18c The Maltings, Gynn Lane, Honley, HD9 6LF

Planning Application REF 2025/91370

1. I am responding to your invitation to offer a response to an outline application for the building of up to 50 houses on land at Gynn Lane, Ref 2025/91370

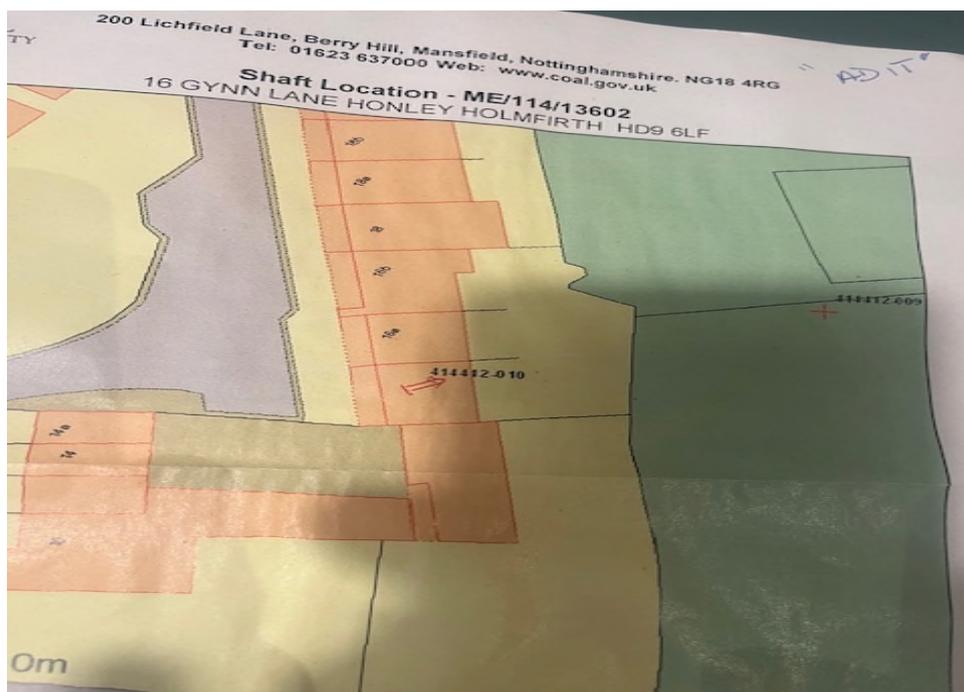
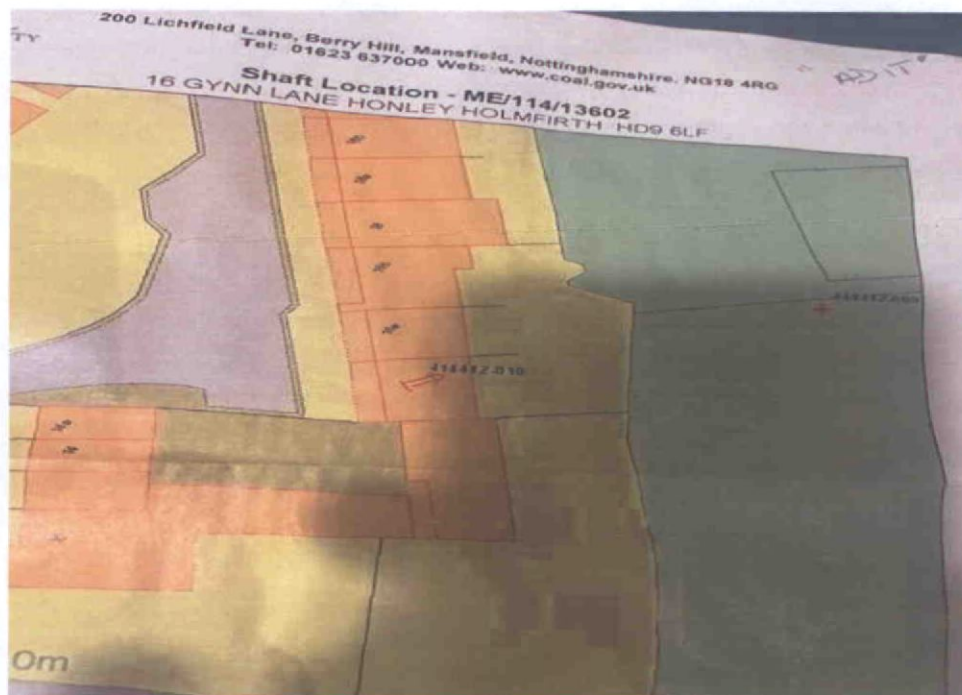
- The Lithos report also notes “a mine entry is also recorded by The Coal Authority in the west of the site... but this was not encountered during the search” I enclose a photograph of the the Coal Authority map showing the site of the mine shaft which the search failed to locate. You will see that the shaft is within 10m of the proposed development site and connected to an adit that sits underneath existing adjacent properties in Gynn Lane.

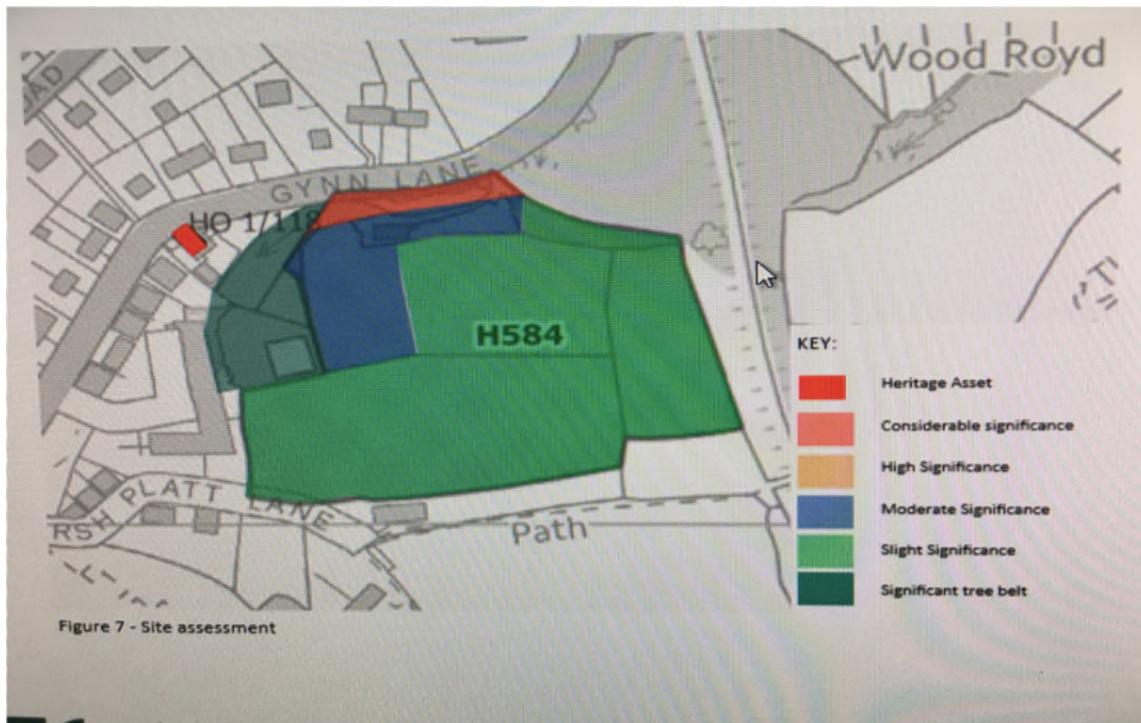
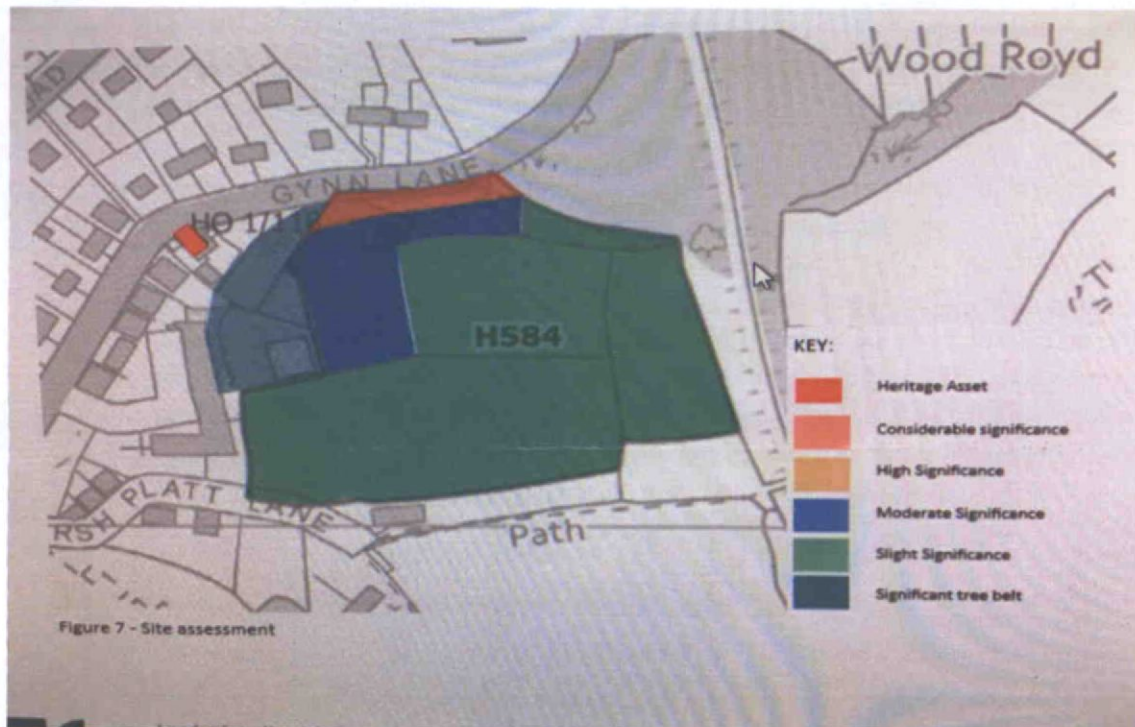
- The recommendations are set out in diagrammatic form as follows:

- This report commissioned by Kirklees Council has one critical implication for the proposed site layout. Comparing the proposed development to the recommendations set out above, which aim to help protect the heritage asset, it is clear that there are 8 properties (numbers 1-8) on the area designated as of moderate significance. In my view this does not maintain the setting of the heritage asset by preserving the agricultural nature of this section of the land. This demonstrates that 50 houses cannot be accommodated on the site if harm to the heritage asset is to be less than substantial

- Both objections could be met by taking out the 11 houses on the N/W border of the site. This would enable a substantial site development and local benefit, without contravening national planning guidance through failure to protect existing housing from risk.
